Colorado Geological Survey	Colorado Geological Survey review of the resubmittal for Homestead North Phase 1 Preliminary Plan SP208 (Amy Crandall, P.E., acrandall@mines.edu):	8/25/2021 1:10:05 PM
----------------------------	--	----------------------------

With the resubmittal documents, we received the revised Preliminary Plan (N.E.S. Inc., August 2, 2021) and the Grading and Erosion Control Plan (J.R. Engineering, June 30, 2021). An updated soil and geology report addressing our previous correspondence or the proposed infrastructure plans (Briargate Parkway and Sterling Ranch Road to include channel crossings) was not provided with the recent referral documents.

COVER SHEET

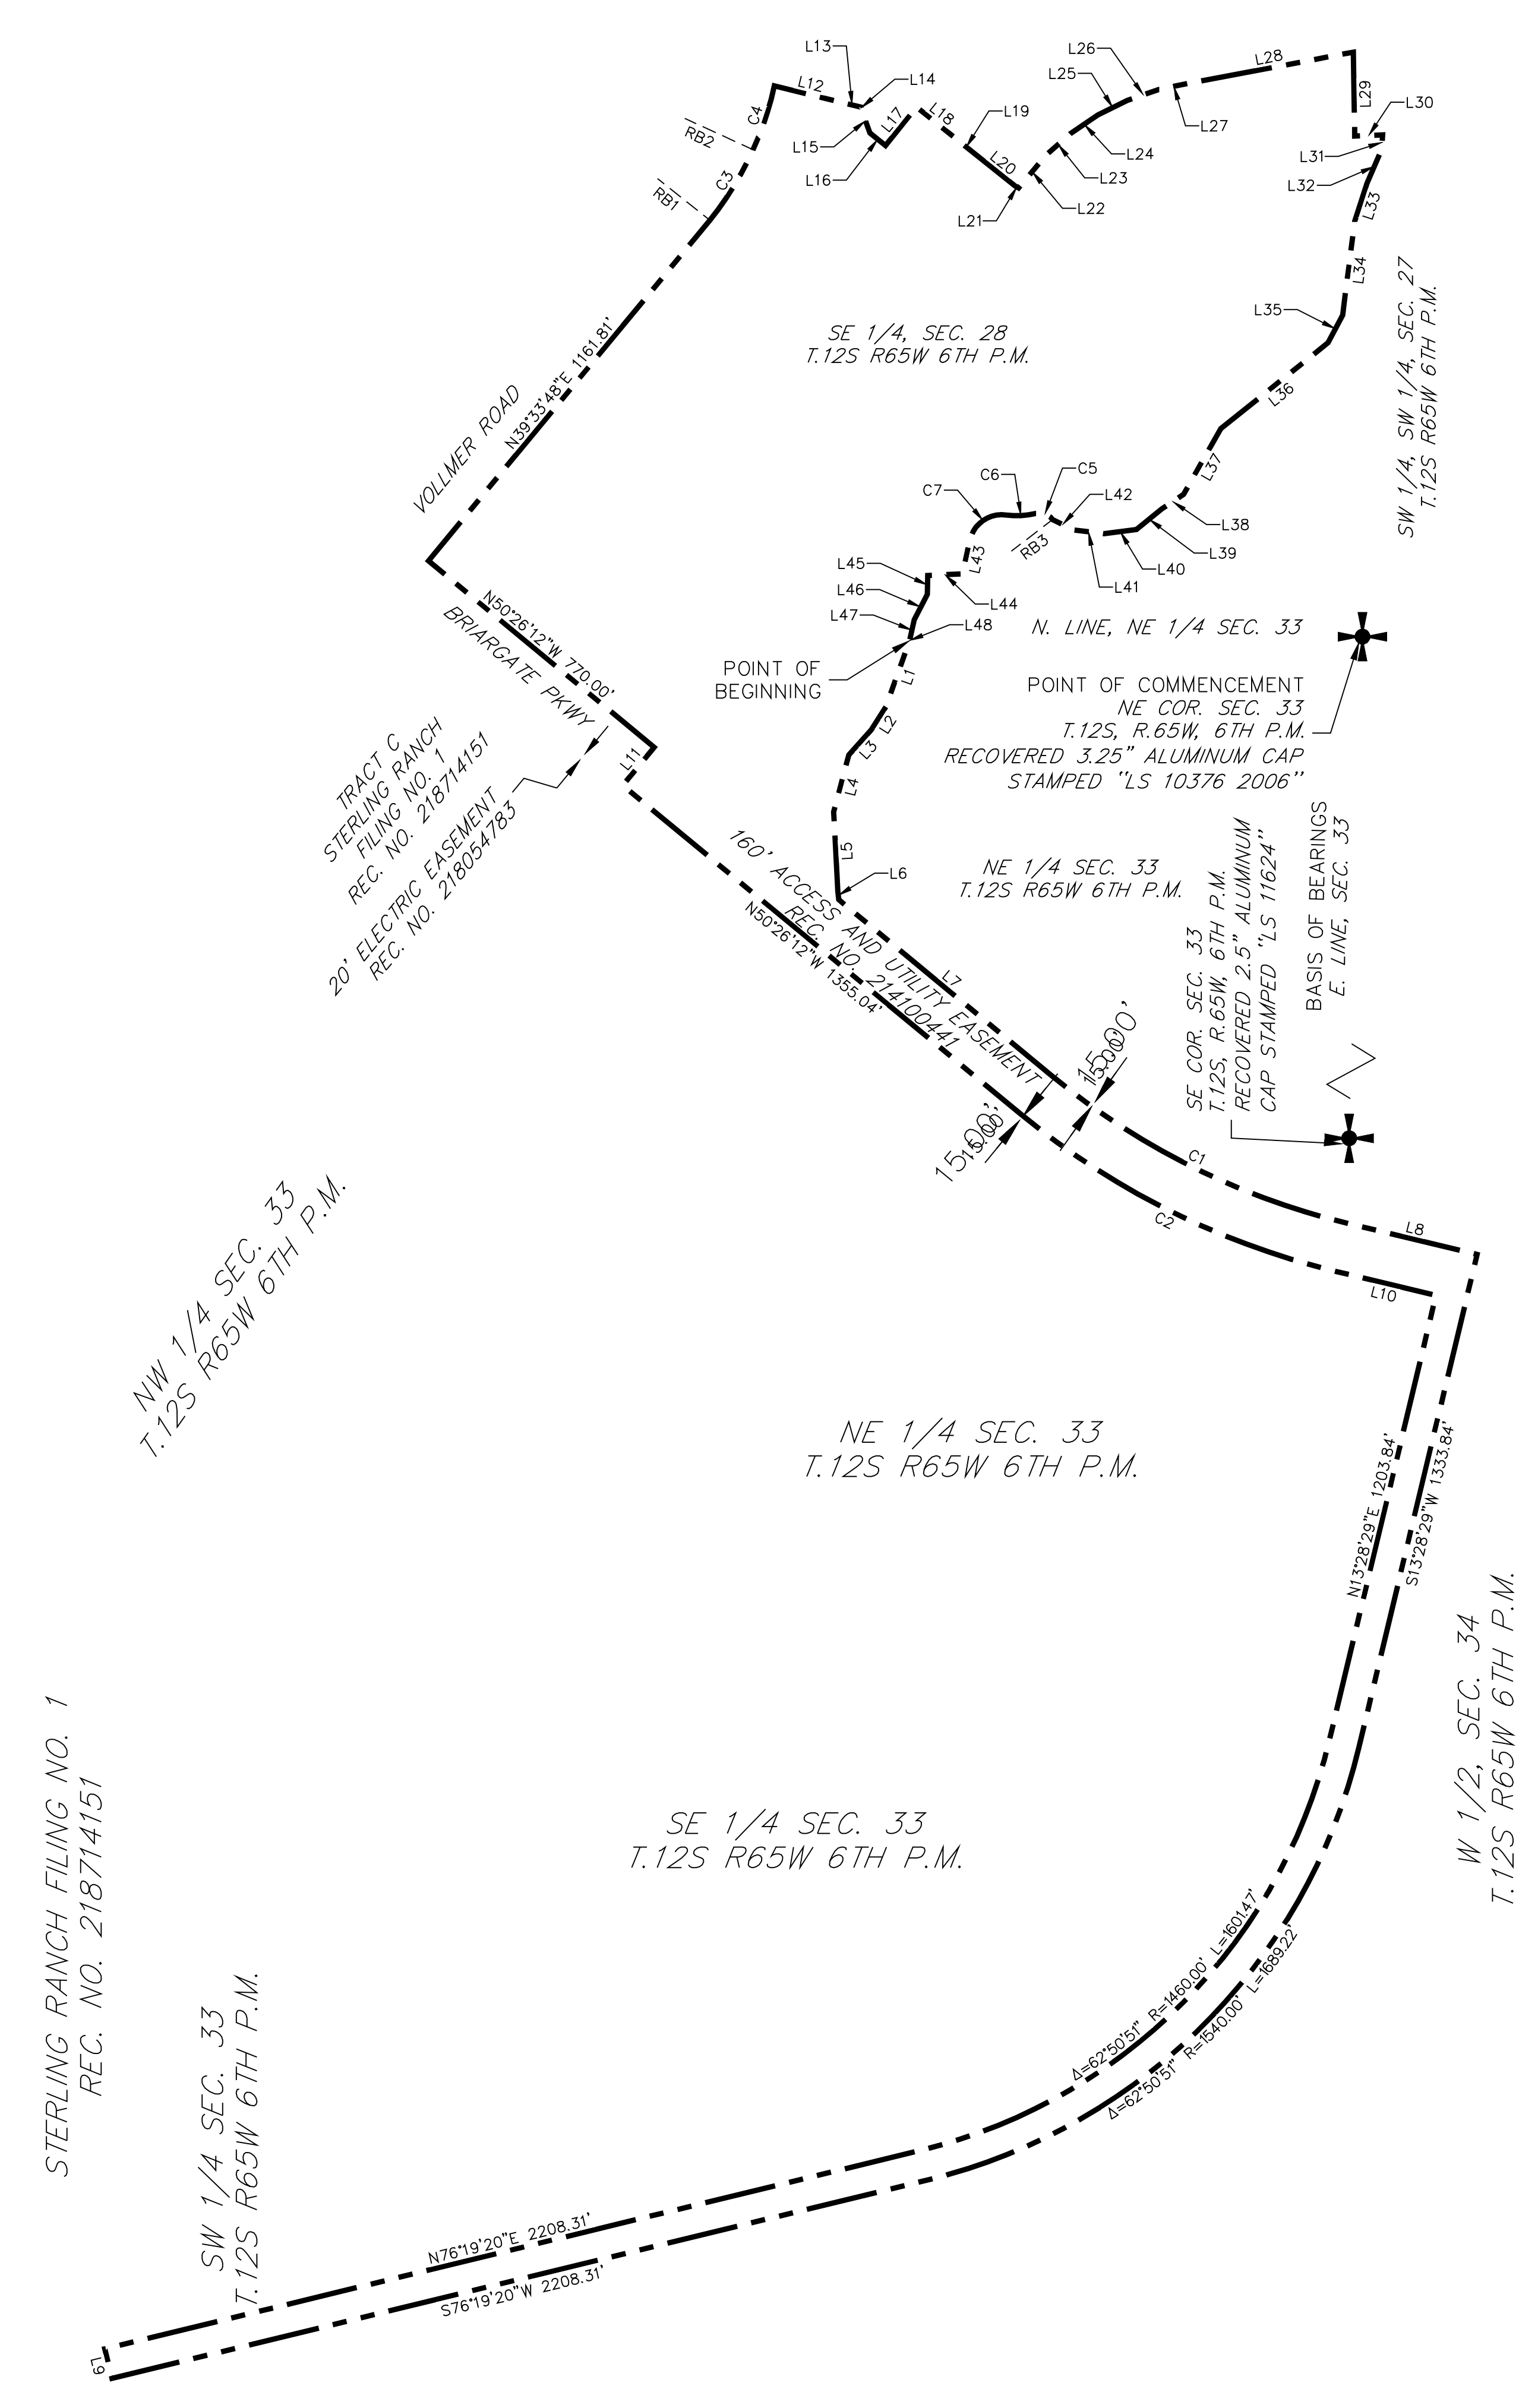
Entech recommends (page 11) subsurface perimeter drains where high subsurface moisture conditions are anticipated, a practice we believe is prudent. Individual foundation perimeter drains are needed around any below-grade (basement) space. According to the geologic hazard disclosure statement on sheets 1 and 25 of the preliminary plan, "In Areas of High Groundwater: Due to high groundwater in the area, all foundations shall incorporate an underground drainage system. Under drains to be maintained by the District." CGS recommends the underground drainage system and maintenance requirements are shown in the plans, and the "District" understands the maintenance requirements throughout the life of the development. The underground drainage system must gravity discharge to a daylight outfall. Please note that individual foundation perimeter drains are intended to handle small amounts of intermittent, perched water and may NOT be used as sole mitigation of persistent shallow groundwater conditions.

include overexcavation of expansive soil or the use of drilled pier foundations. According to the geologic hazard disclosure statement on sheets 1 and 25 of the preliminary plan (N.E.S, Inc., Revised June 2, 2021), "In Areas of Expansive Soils: Incorporate special foundation design." Therefore, the applicant should evaluate and discuss what mitigation option will be performed for expansive soil before final plans are approved.

JR Response: Noted, subsurface perimeter drains will be used.

JR Response: Noted, over excavation or pier foundations will be used to mitigate expansive soils
